9 December 2024

**SUBMISSION from 220 and 220A Fitzgerald Avenue, Maroubra
Proposed development at 195-213 Fitzgerald Avenue and 40-64 Yorktown
Parade, Maroubra - State Significant Development Application (SSD-71454960)**

Core 1A Core 1B Core 1C Core 1D Core 2A Core 2B Core 2C Core 2D

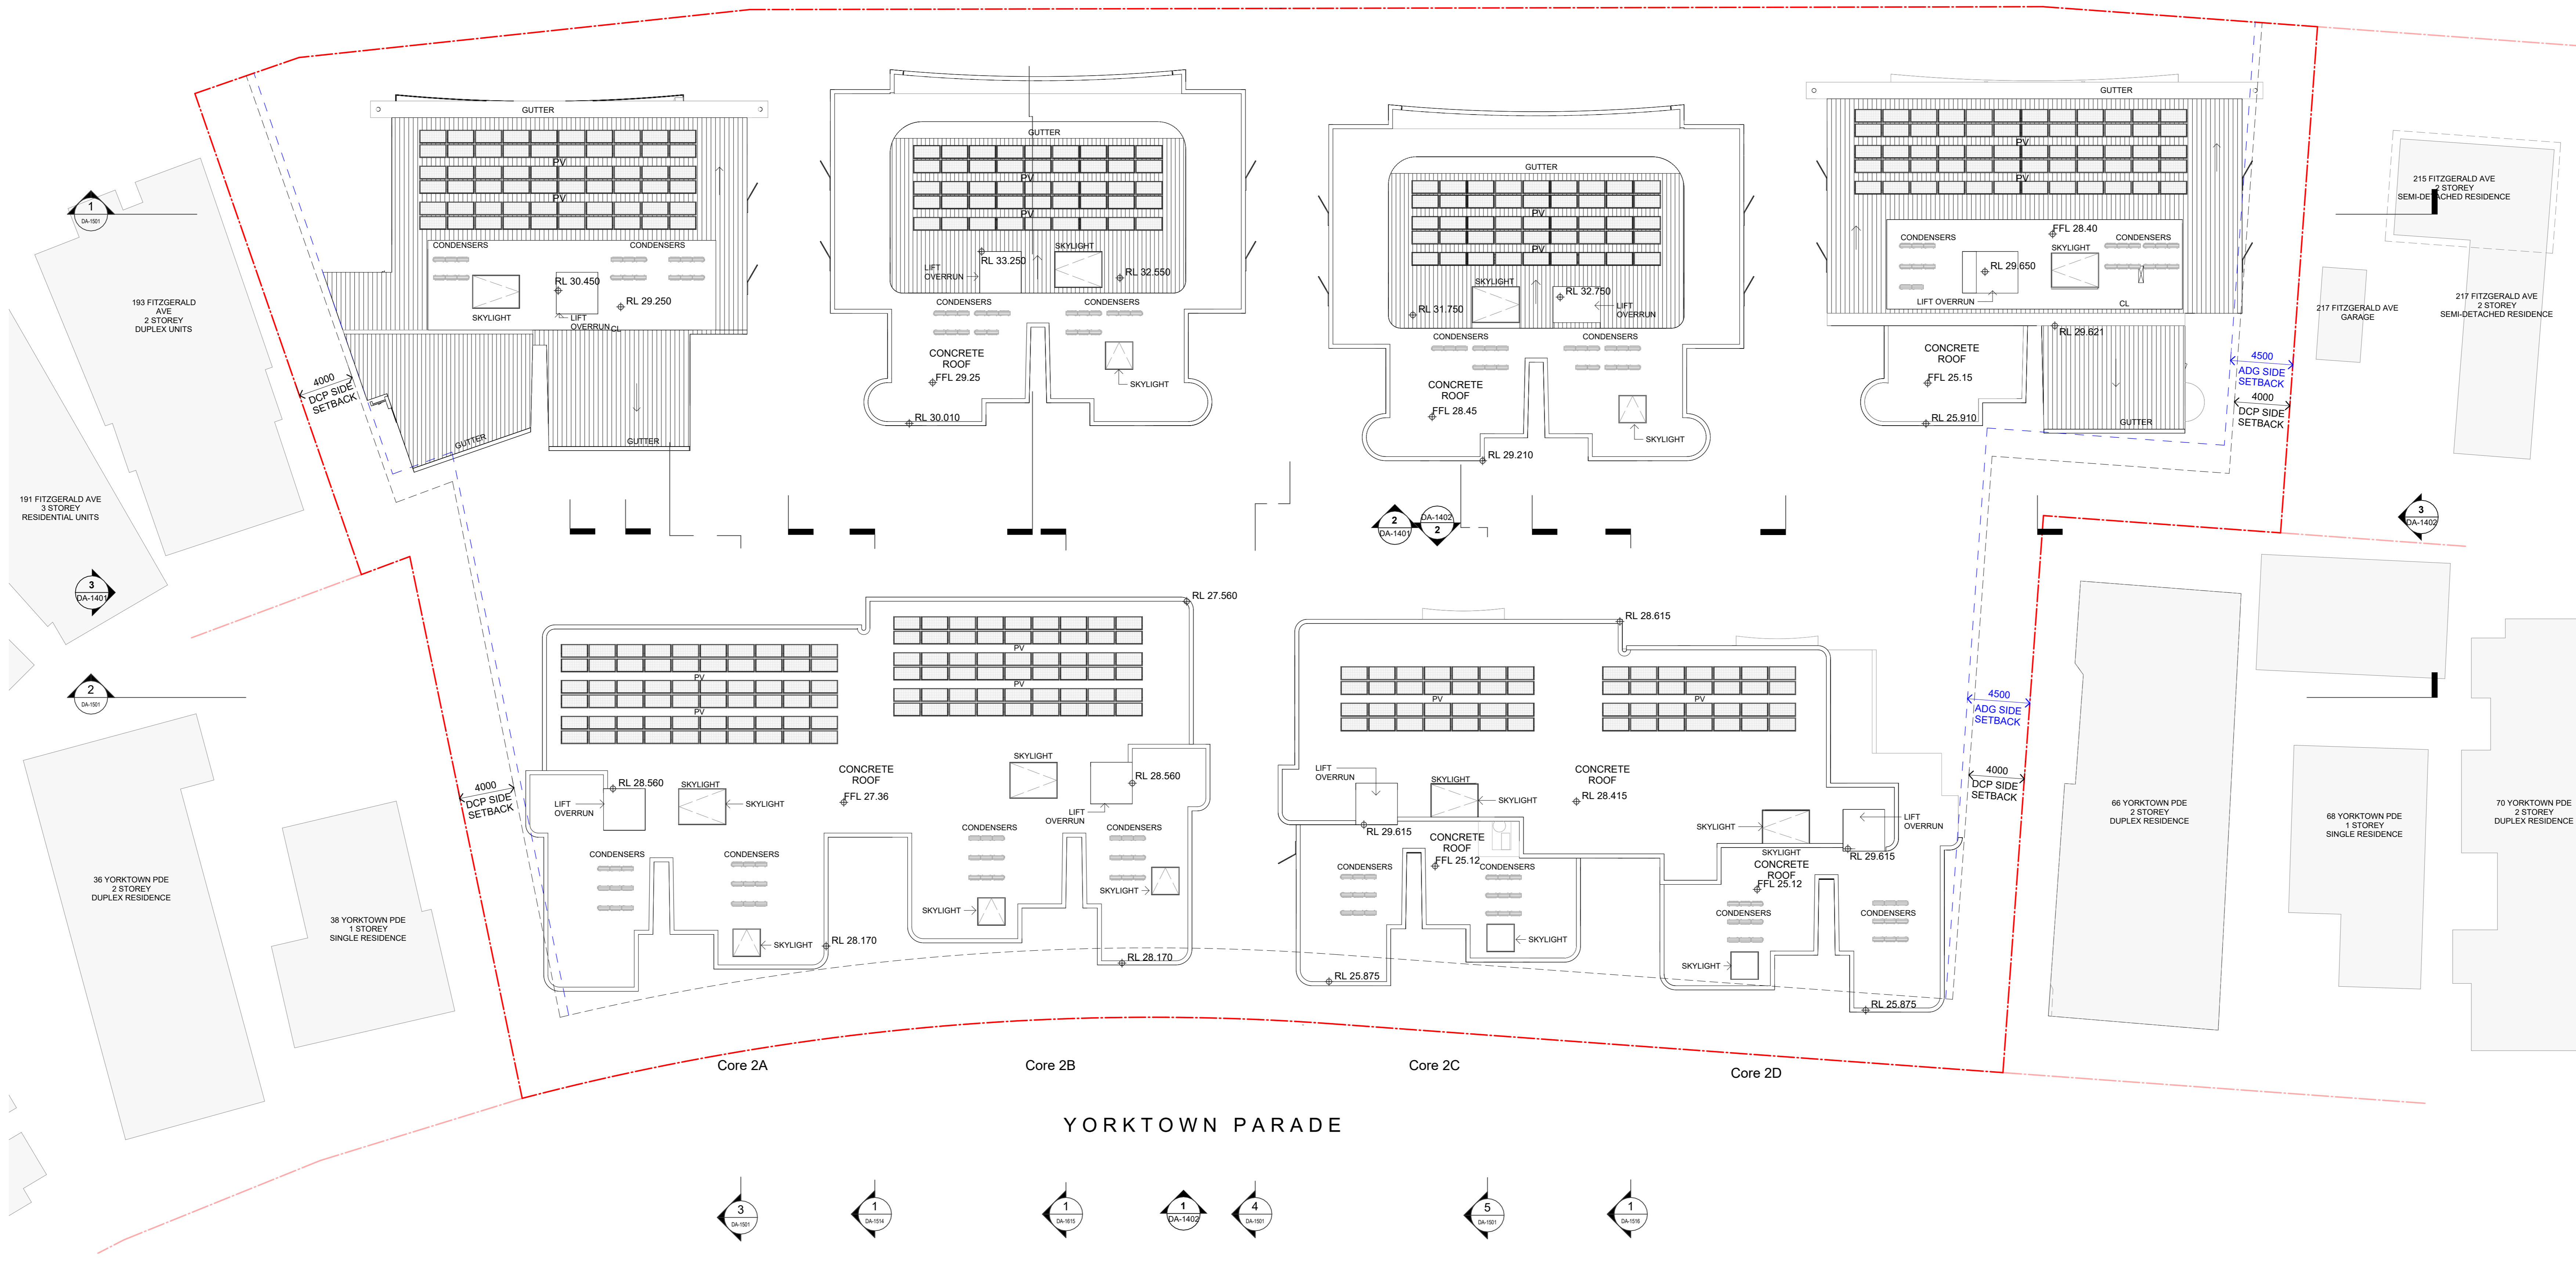
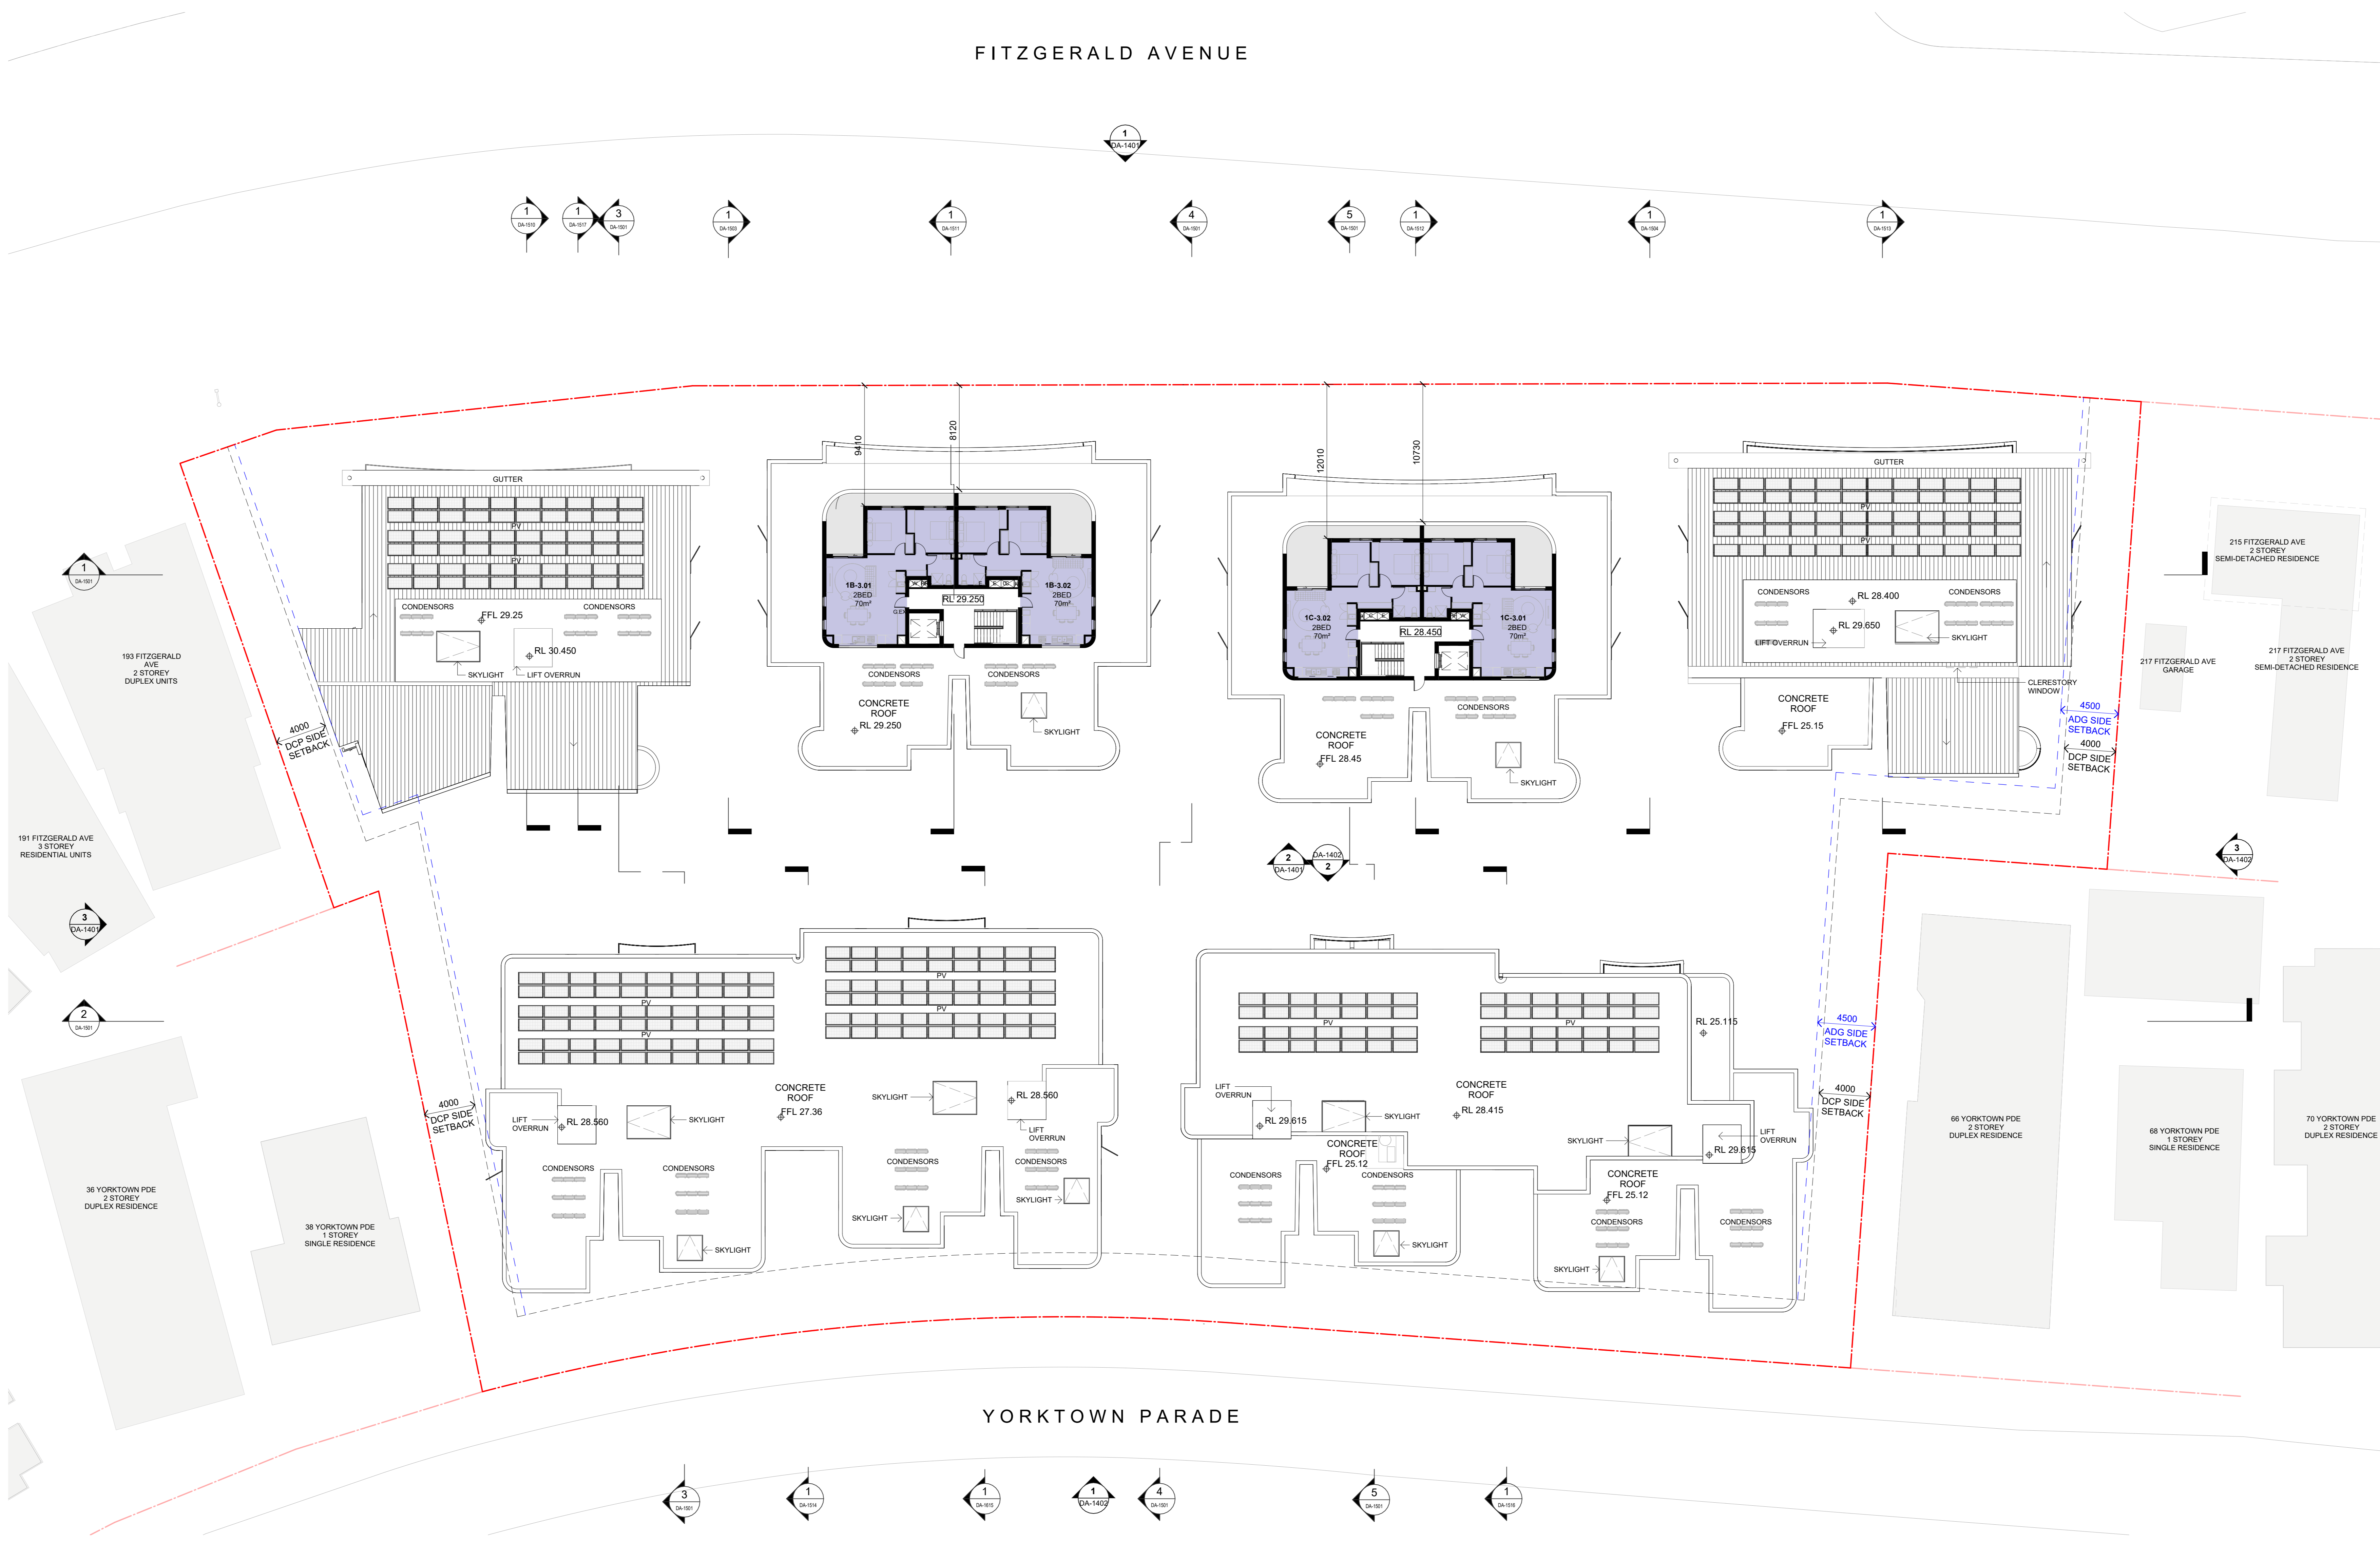
- Building heights range up to 4 storeys [Buildings 1B & 1C opposite my client's property] and 15.85m, in exceedance of the 2-storey character within the local area, and which significantly exceeds the Randwick LEP's 9.5m building height standard.

My client's concerns relate to privacy impacts from the non-compliant 4th storey within Building 1B & 1C which is opposite their properties.

My clients are concerned that the position of these dwellings and the inclusion of north / street facing balconies which have the potential to adversely impact the privacy and amenity of my clients' properties and those adjacent. No screens are proposed to these balconies facing Fitzgerald Avenue. In this regard we note the objective (c) of Height of buildings standard is:
